Bruce Hunter
905/50 Murray Street
Pyrmont, NSW 2009
17 January 2017

**Objection to the proposed redevelopment (SSD 7874) of Harbourside Shopping
Centre with Residential Tower**

Bruce Hunter - SSD 7874 Objection - Page 2

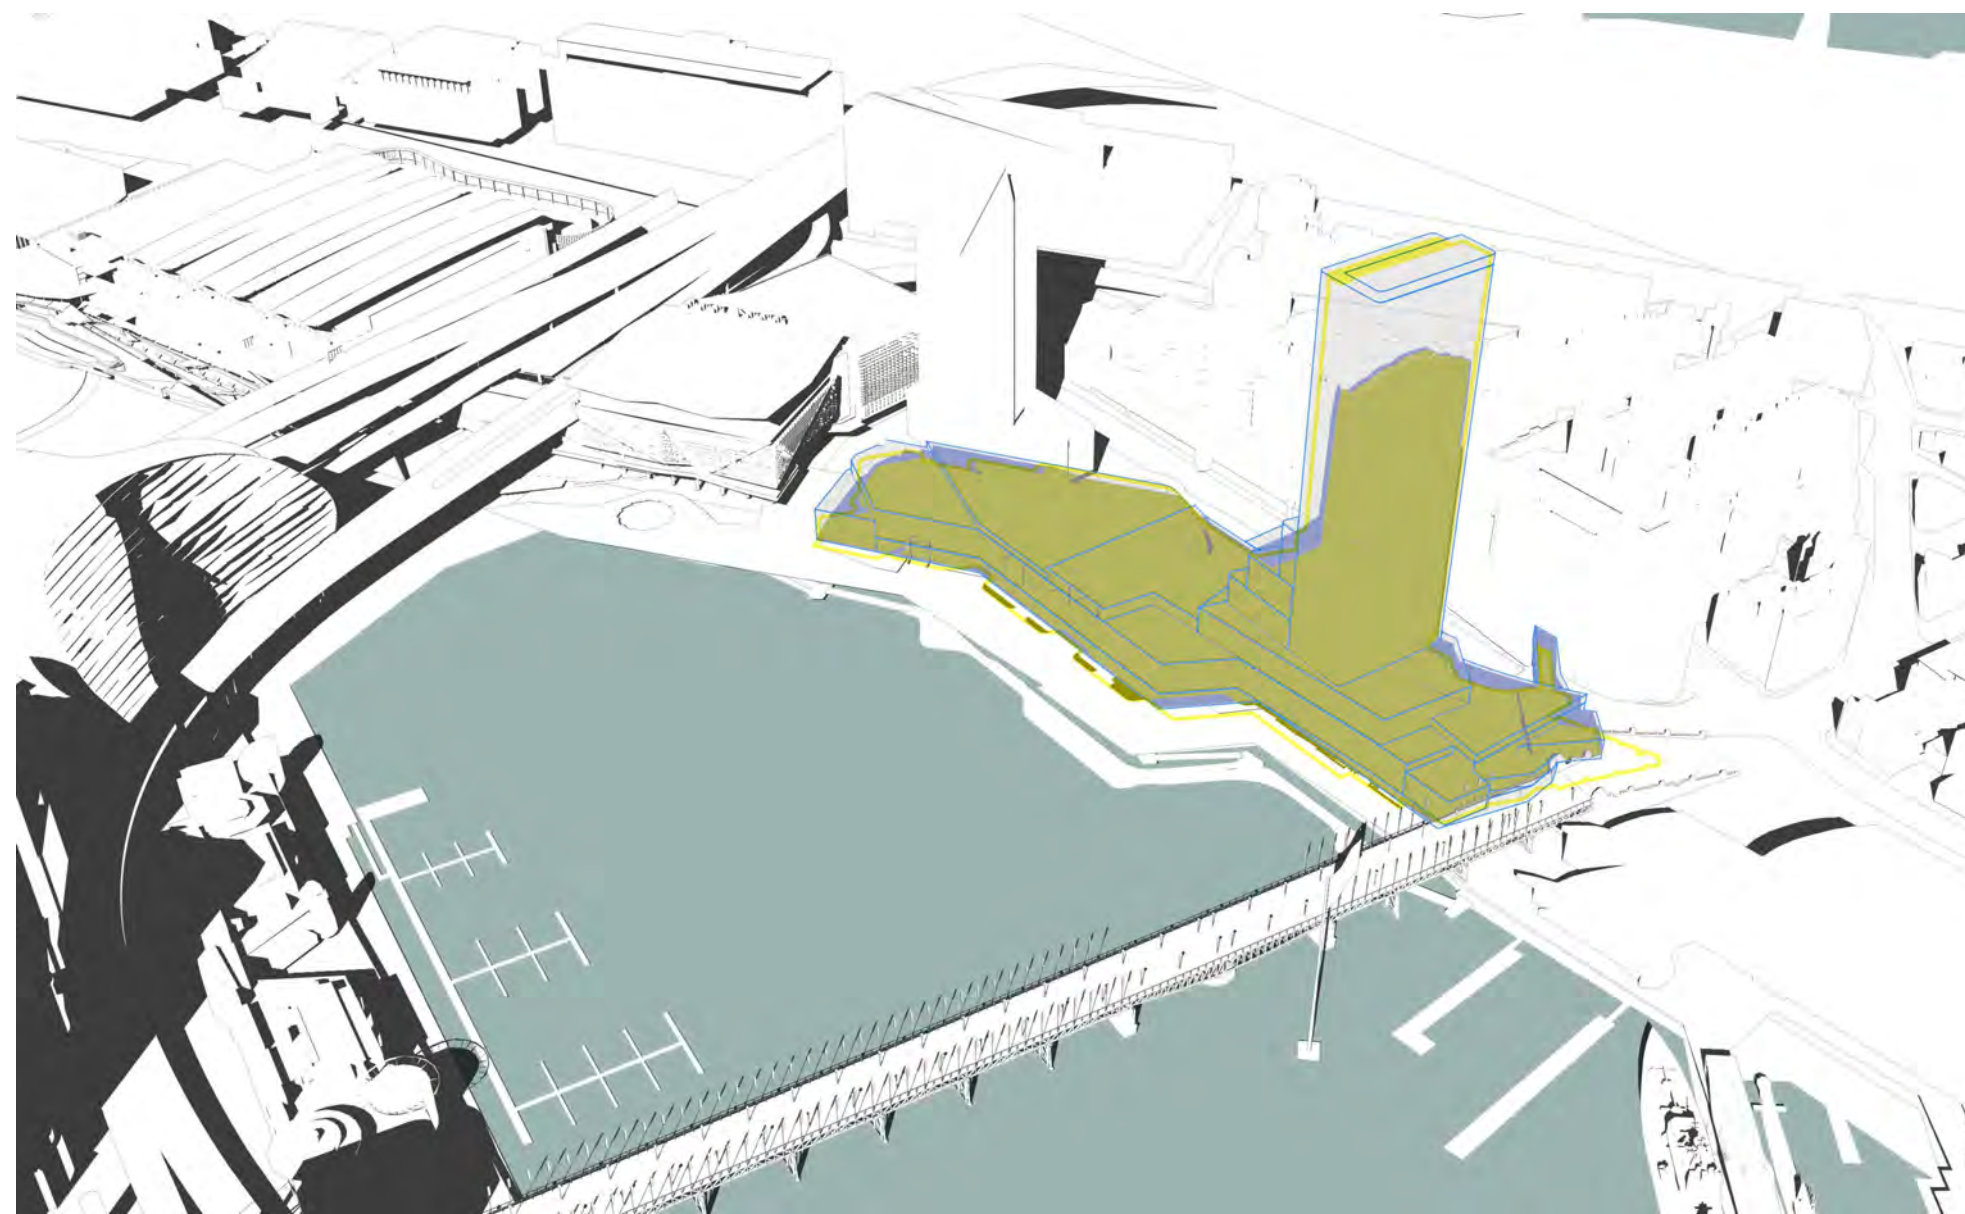
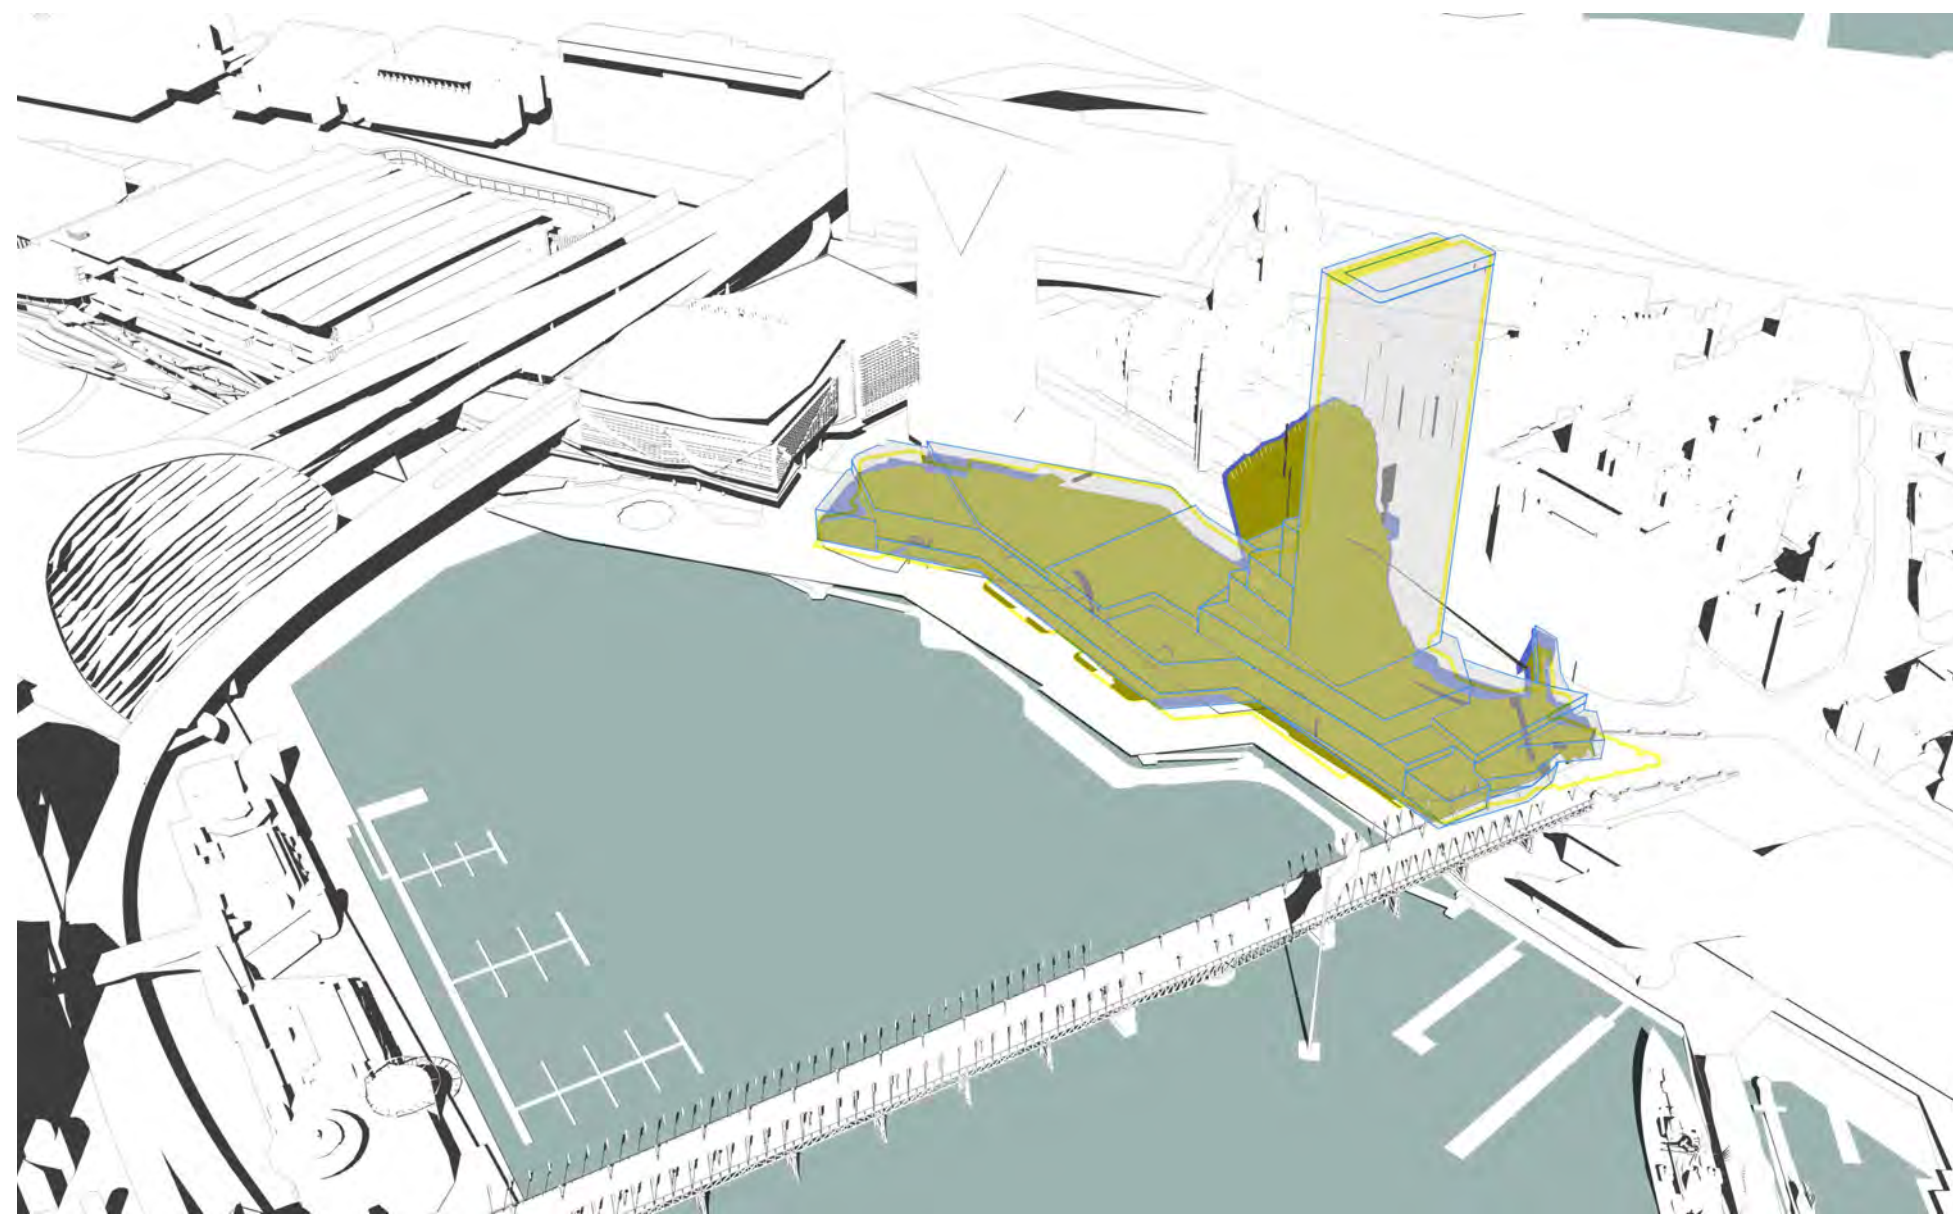
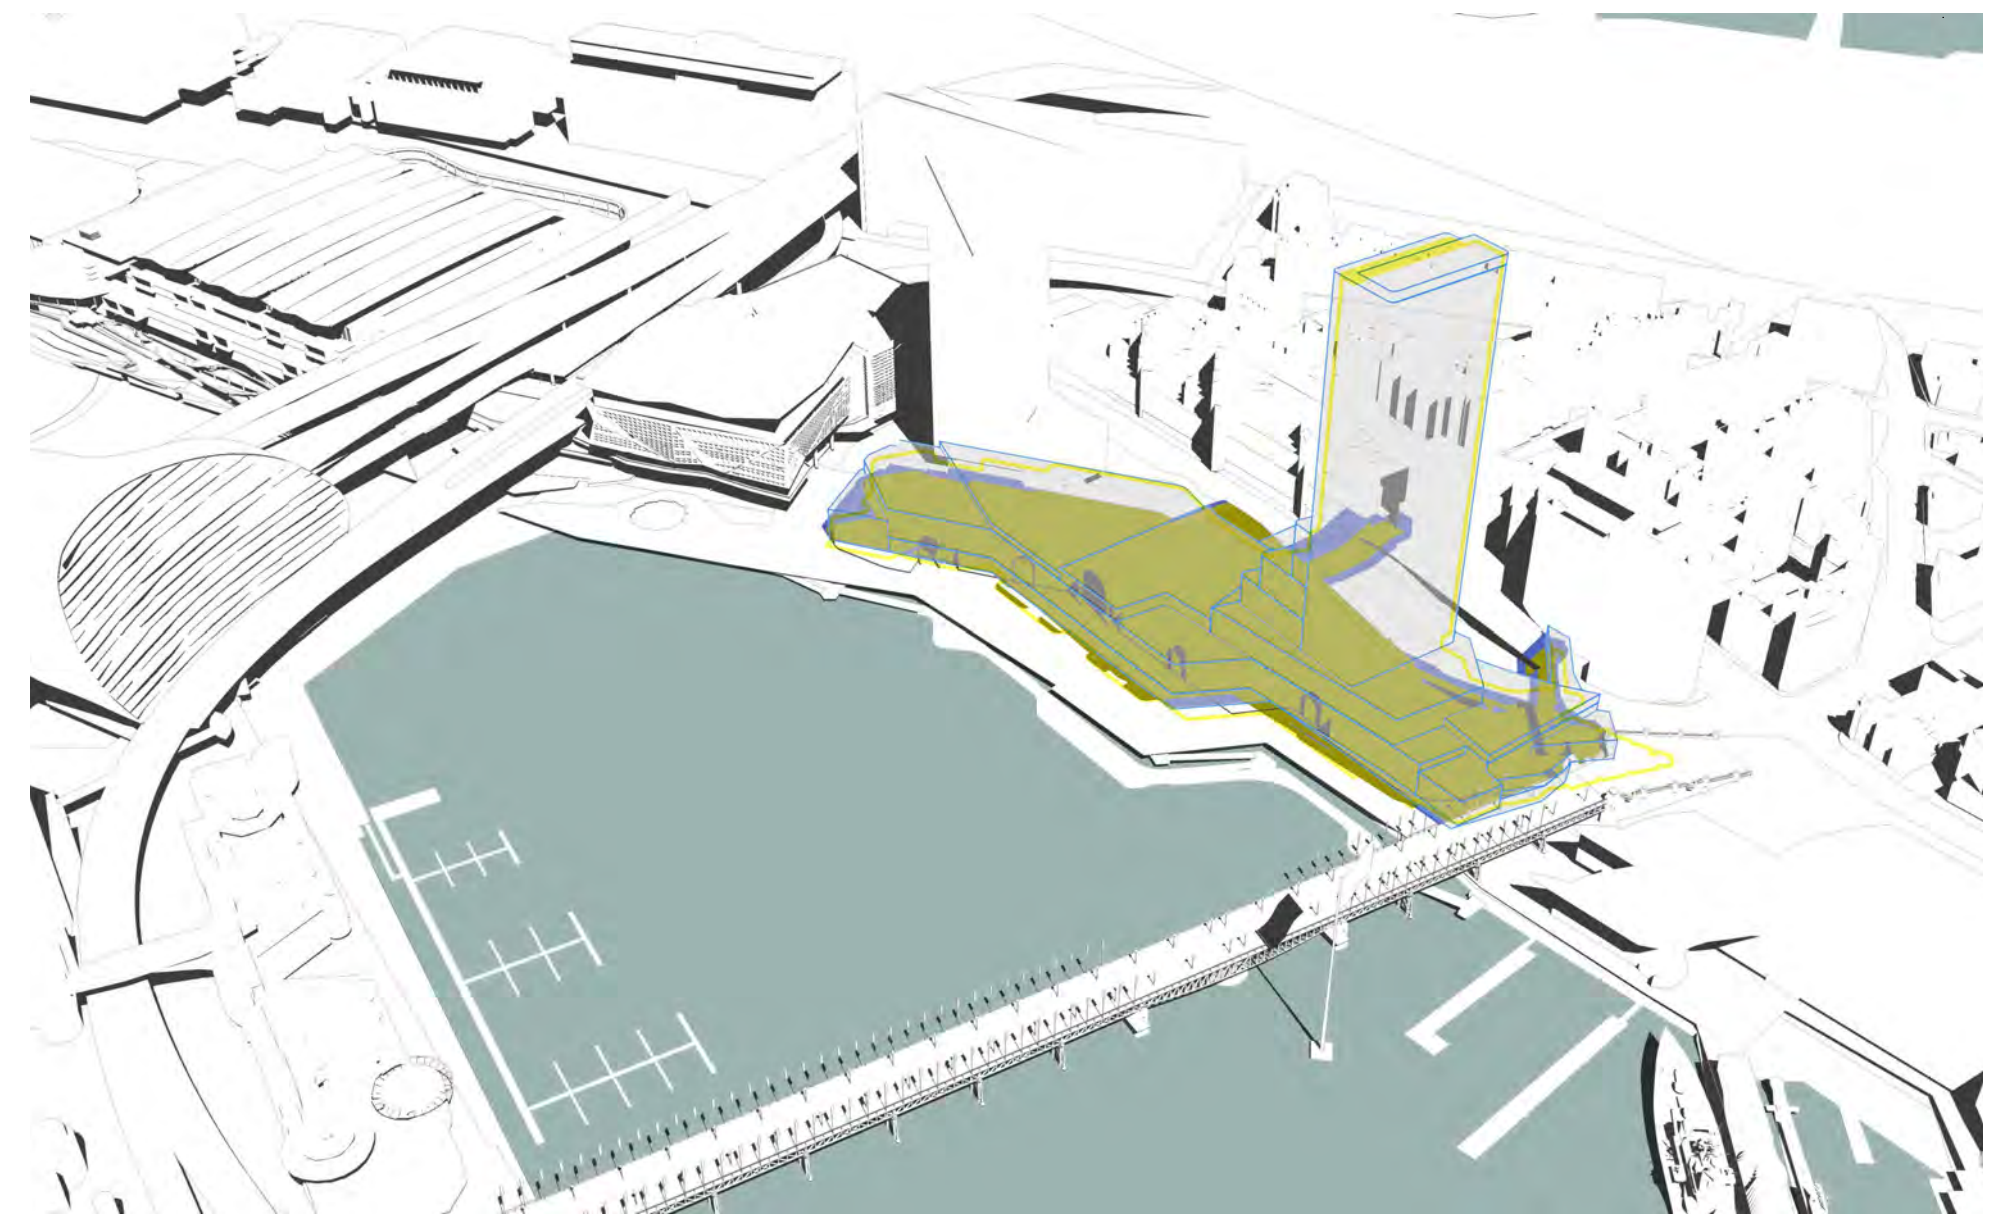
2. There is no justification for the tower included, with the shadow diagrams showing significant shadow impact on Darling Harbour and the residential areas on the western side towards Pyrmont.
